Our Ref RG/SPRUSTINGTON6.1
Your Ref A/23/15/OUT

Mixed-Use Development on Land south of A259 New Road and East of Brook Lane, Angmering, West Sussex

We write, on behalf of our client Store Property Investments Ltd to comment on the proposed development at the above site. Specifically, our comments below are in relations to the Road Safety Audit Report (RSA1) undertaken by Fenley Partnership on the 6th April 2015 and uploaded onto the Arun District Council planning portal on the 4th June 2015.

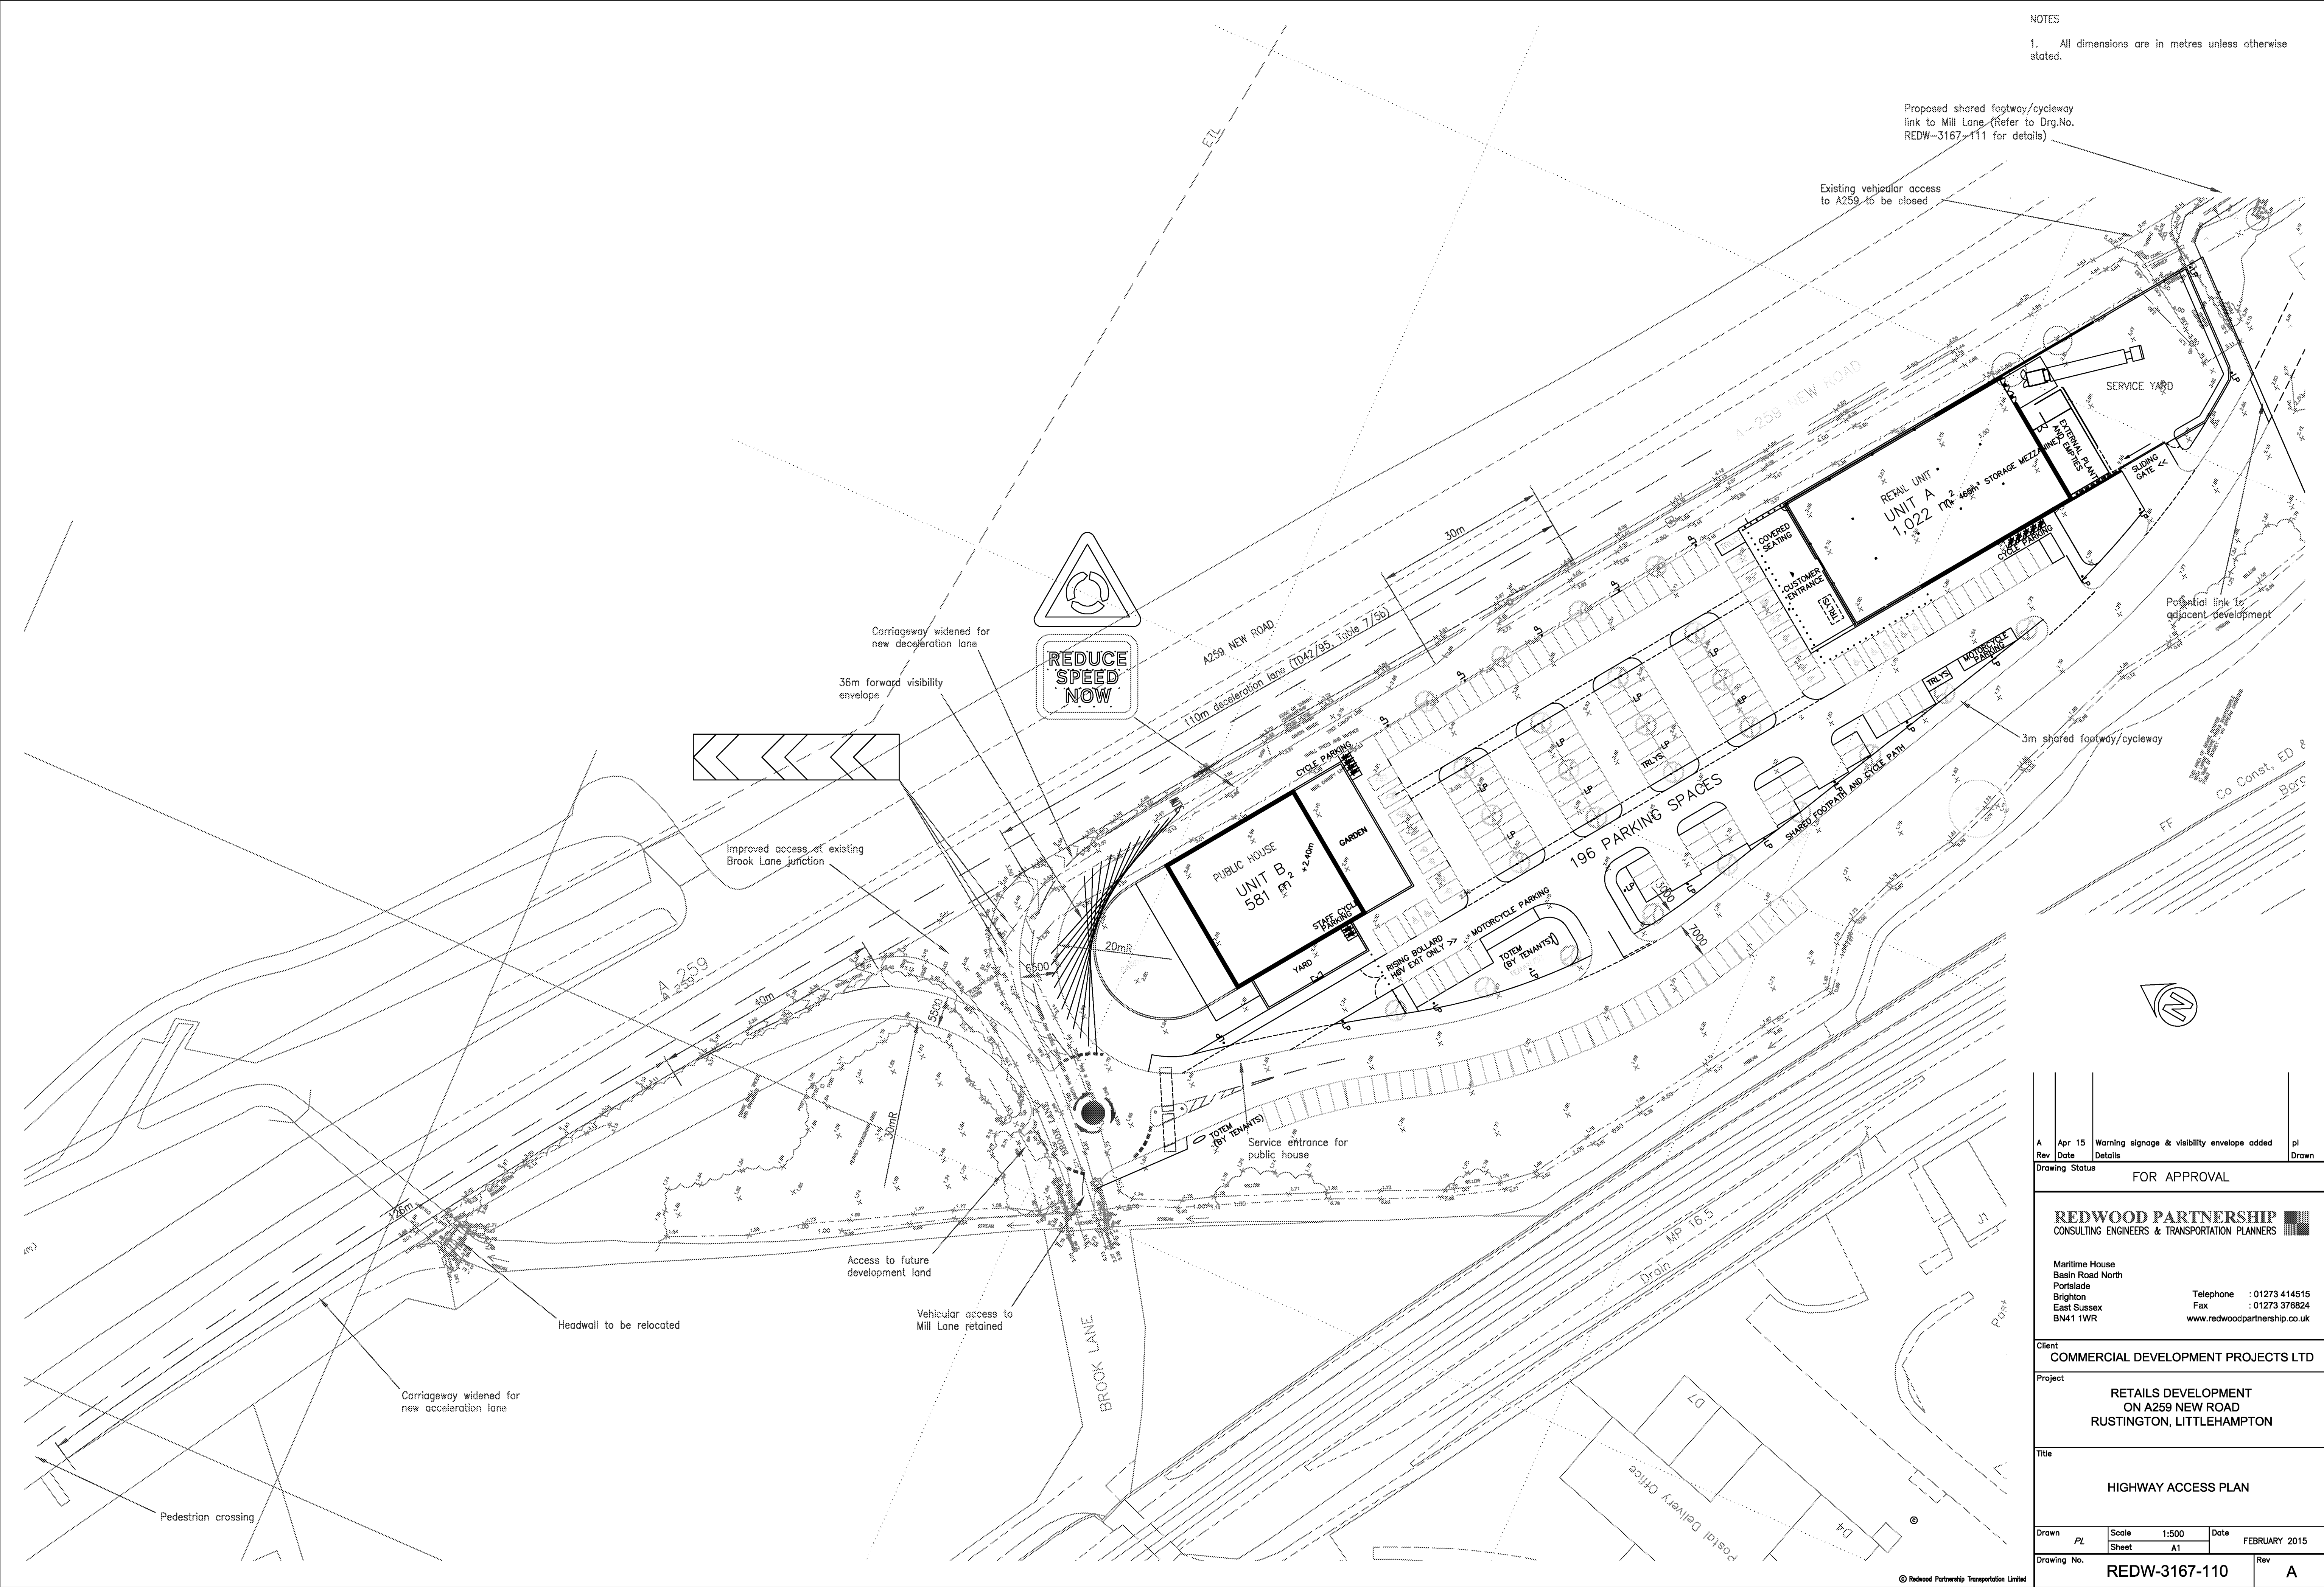
- A.2.1 Tight entry corner radius – states that vehicles could be travelling at speeds in excess of that required to safely negotiate the 20m radius, suggests chevrons and warning signs that the designer agrees to and provides drawing illustrating this. We would suggest that it is questionable whether this is sufficient mitigation to justify the departure from standards;

- A.3.1 Forward visibility to the roundabout is restricted – states that visibility from the deceleration lane is restricted to c50m by the building line of the pub and could be further restricted should a fence be erected around the associated grounds, suggests warning signs and that the pub be restricted from erecting a fence but whilst the designer agrees to the signs they state that pub will have a boundary wall around the garden. I would suggest that this lack of visibility combined with the insufficient corner radius could present a safety issue for shunt type accidents;
